Comments from BOBLAF regarding the Virtual Site Inspection Plan (REP2-046)

Drawing Title  
**Visual Receptors - Representative Viewpoints & Rights of Way**

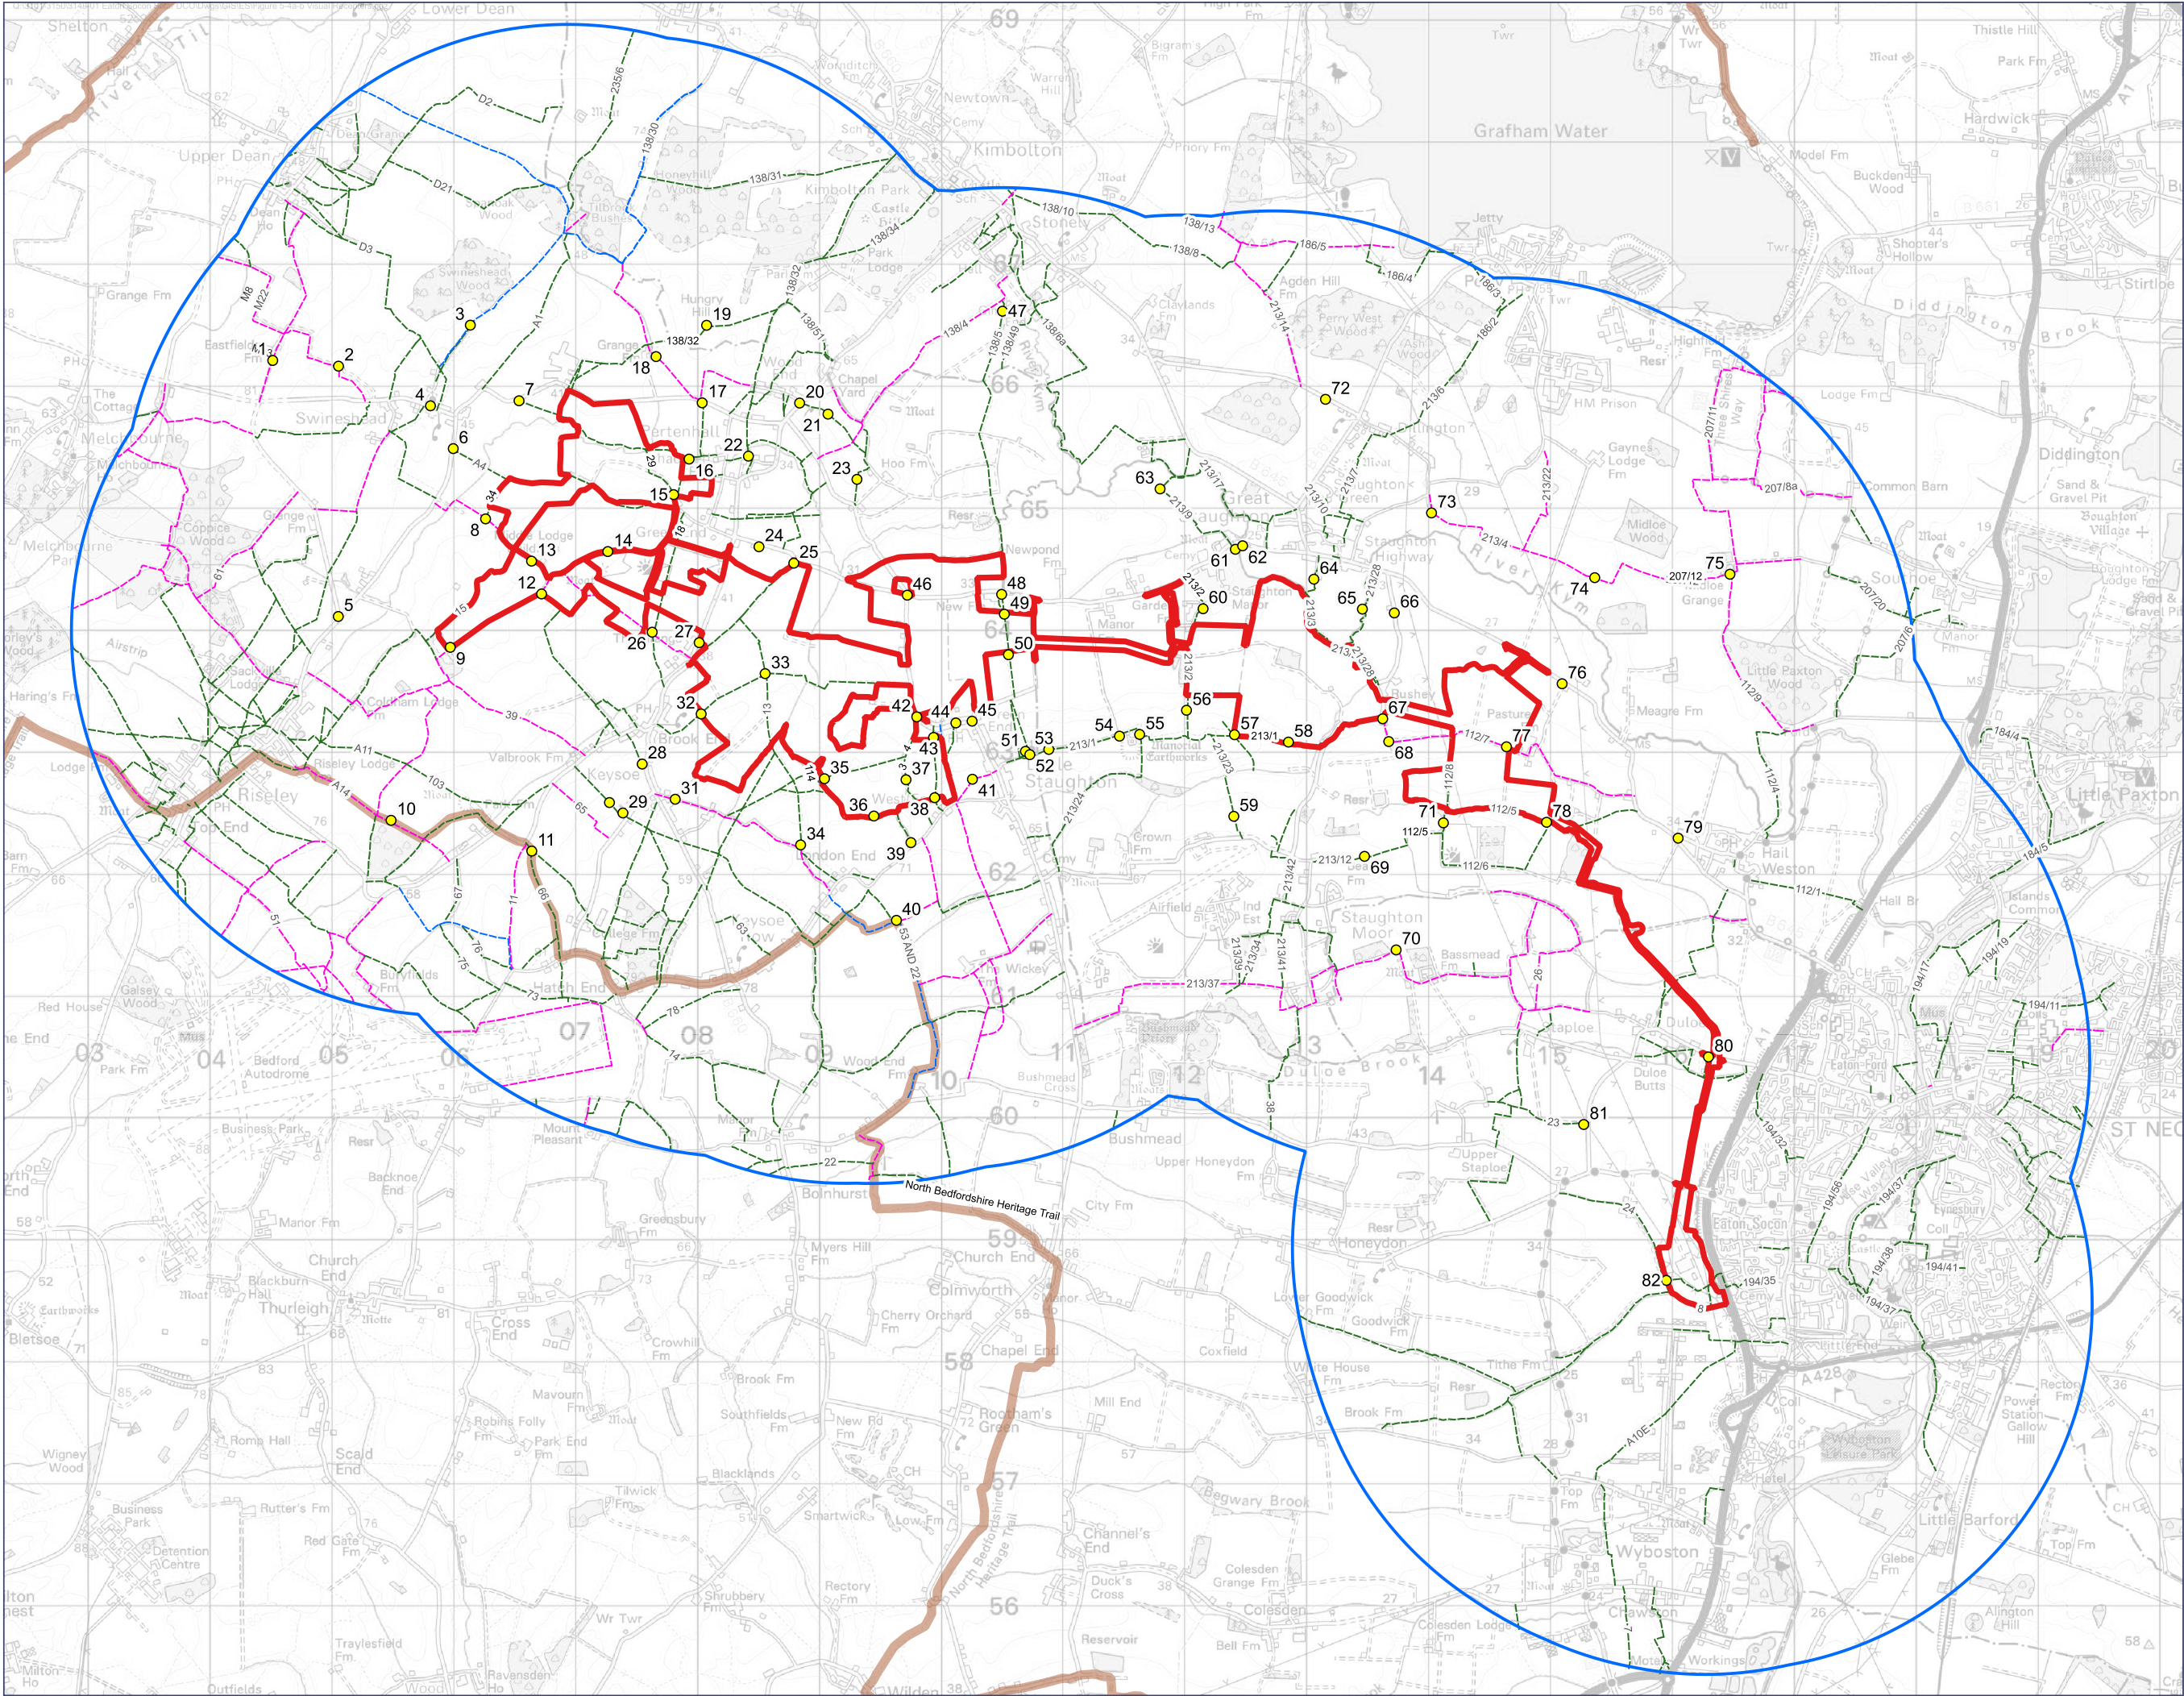
Pertenhall BW 26 and Bolnhurst & Keysoe BW 37 (APP-121 Masterplan sheets d and c, APP-010 Streetworks plan sheets 1, 2 and 3, APP-160 Outline PROW mgmt plan and APP-070 Visual Receptors Figure 5-4a)

This suggestion is essentially Survey Route 9 (a and b), although extended further to the west (to Viewpoint 9 in the LVIA – APP-130).

The BHS has set out its views on the coverage of this bridleway in the virtual site inspection plan and we support their position. In particular, we support the request for rider eye level recording and for an assessment of the banksmen's lines of sight.

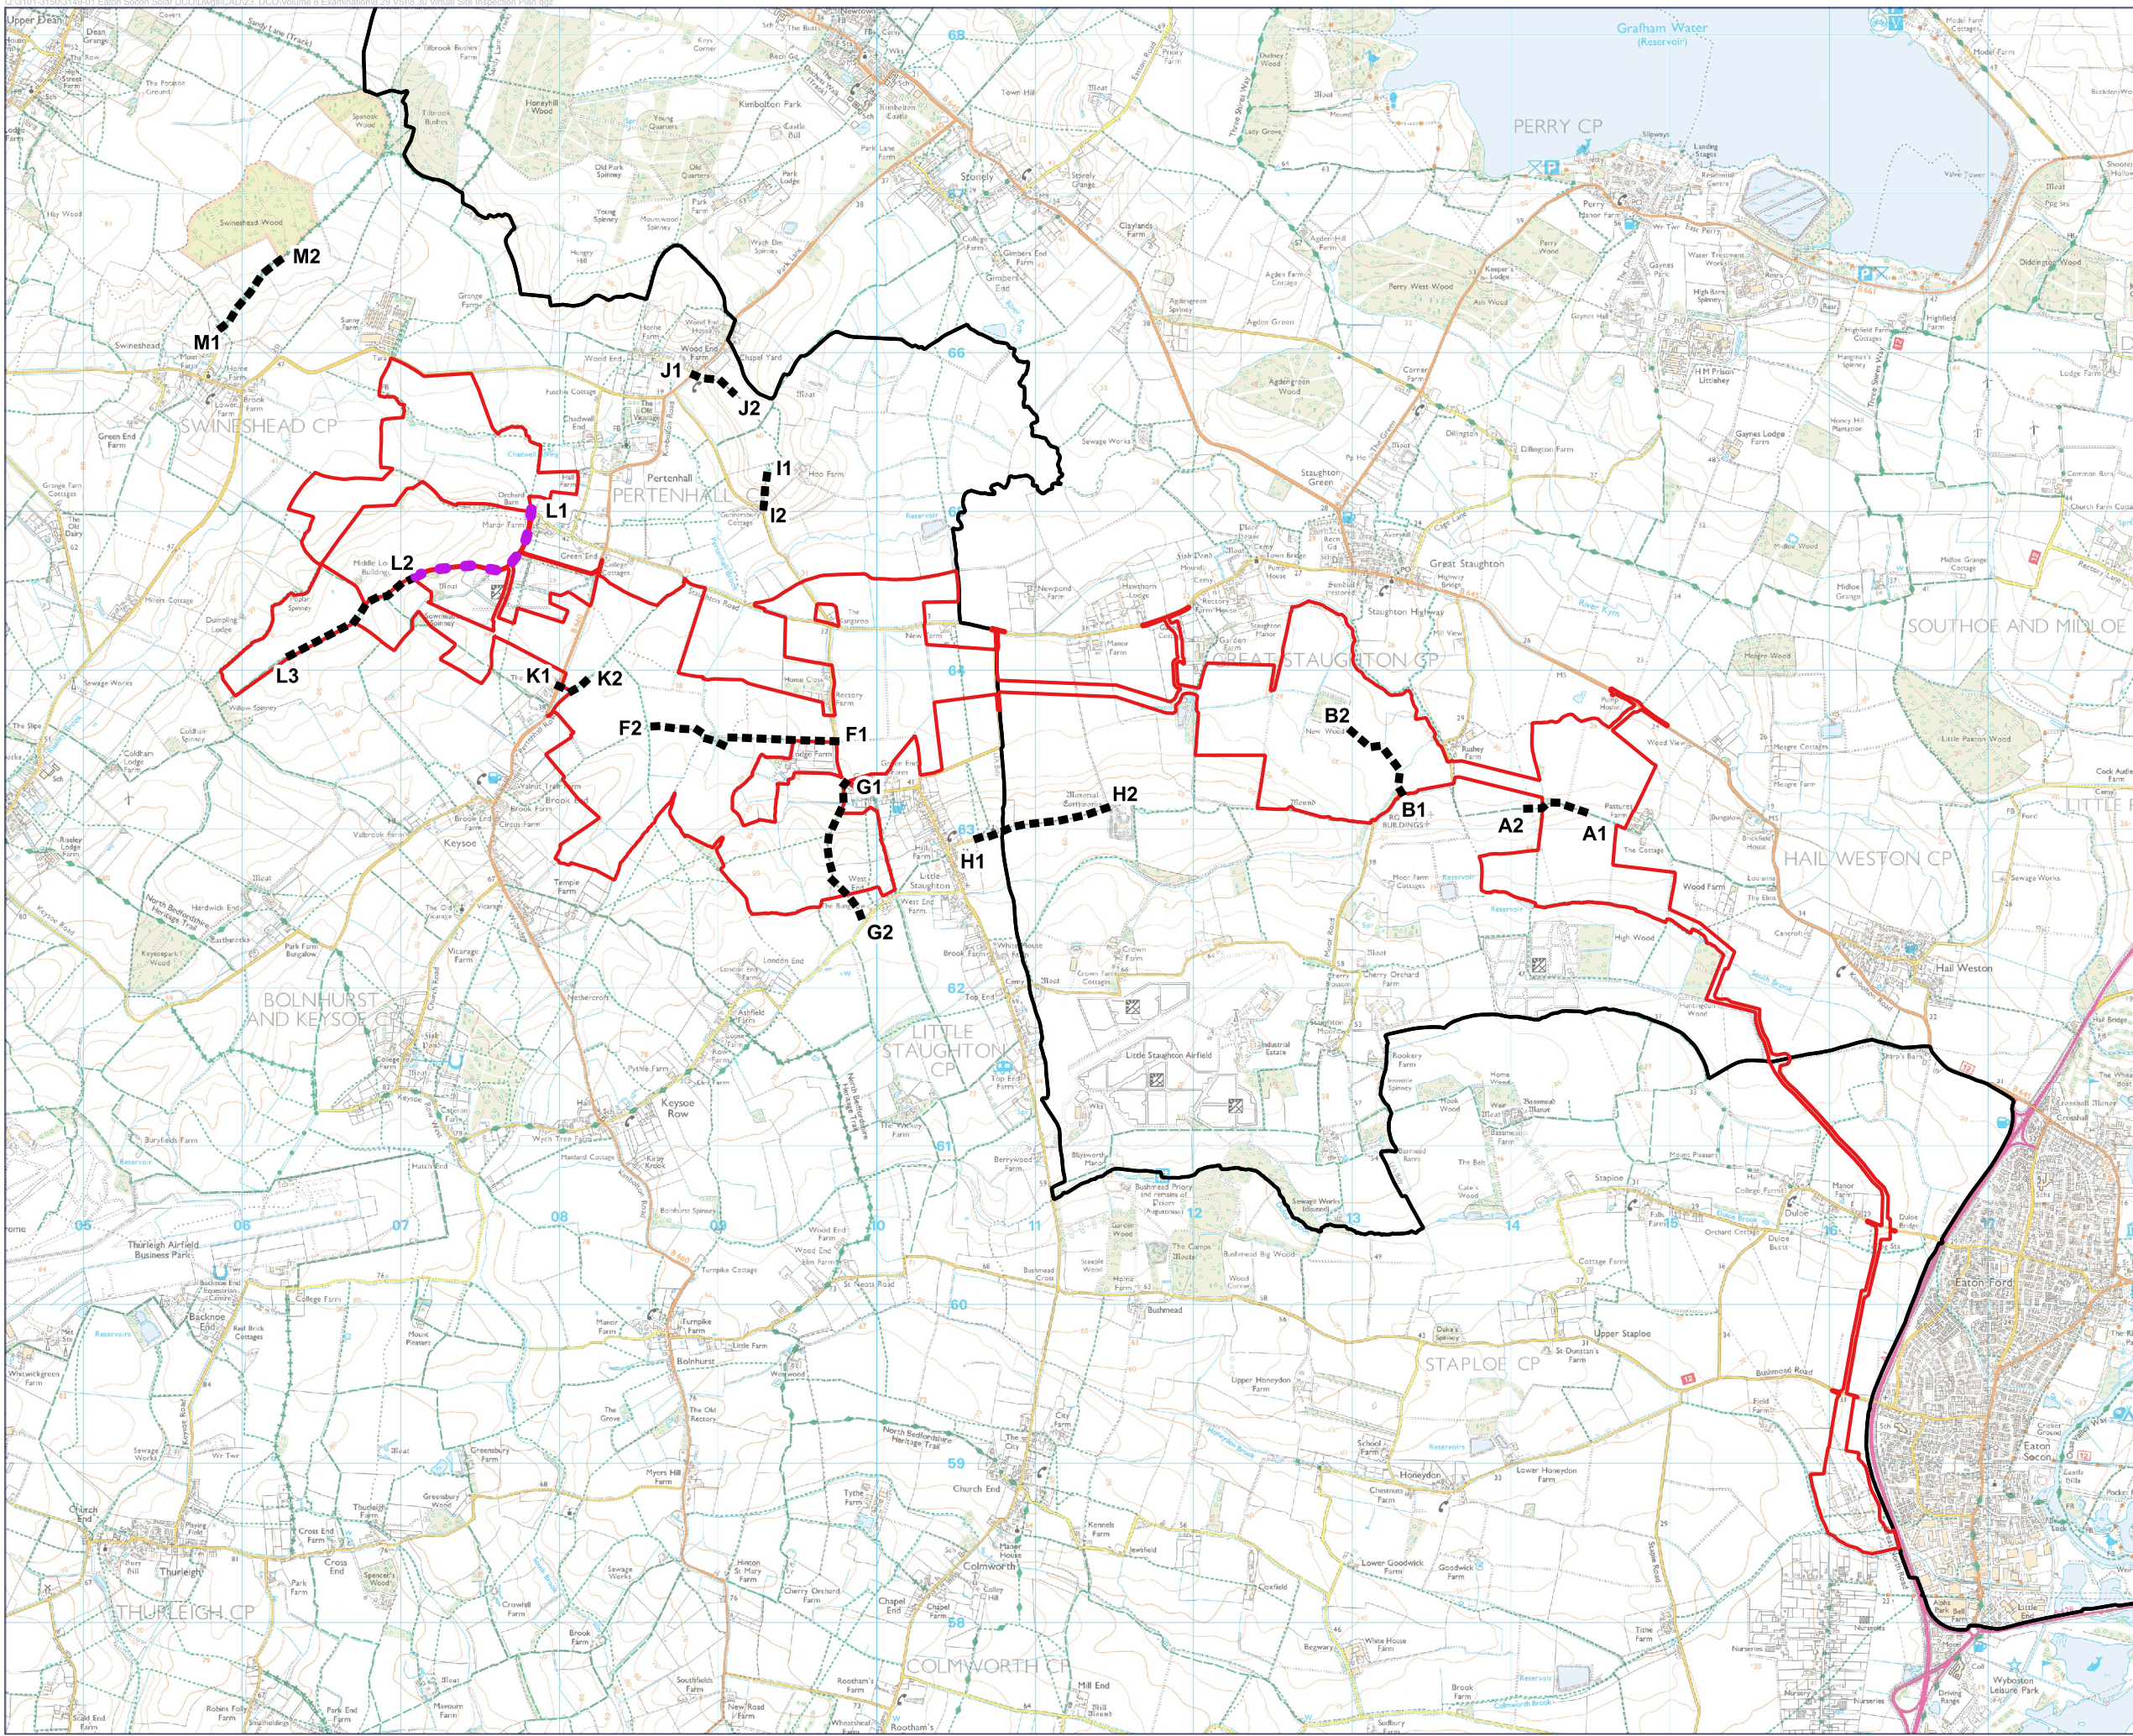
The 'crossroad' junction of B&K FP13 and B&K FP47 within Site B – this is viewpoint 33 in APP-129 and APP-135.

This point is close to point F2 at the western end of Survey Route 3. Whilst it may just be a matter of the granularity of the map, it does look as if the Survey will start slightly to the east of the crossroad junction. BOBLAF recommends that the Survey should start just to the west of the junction and that care should be taken to ensure that the views in all four directions at that crossroad are recorded. Ideally, the operator would walk a few feet in either direction on FP13 as well as along FP47.
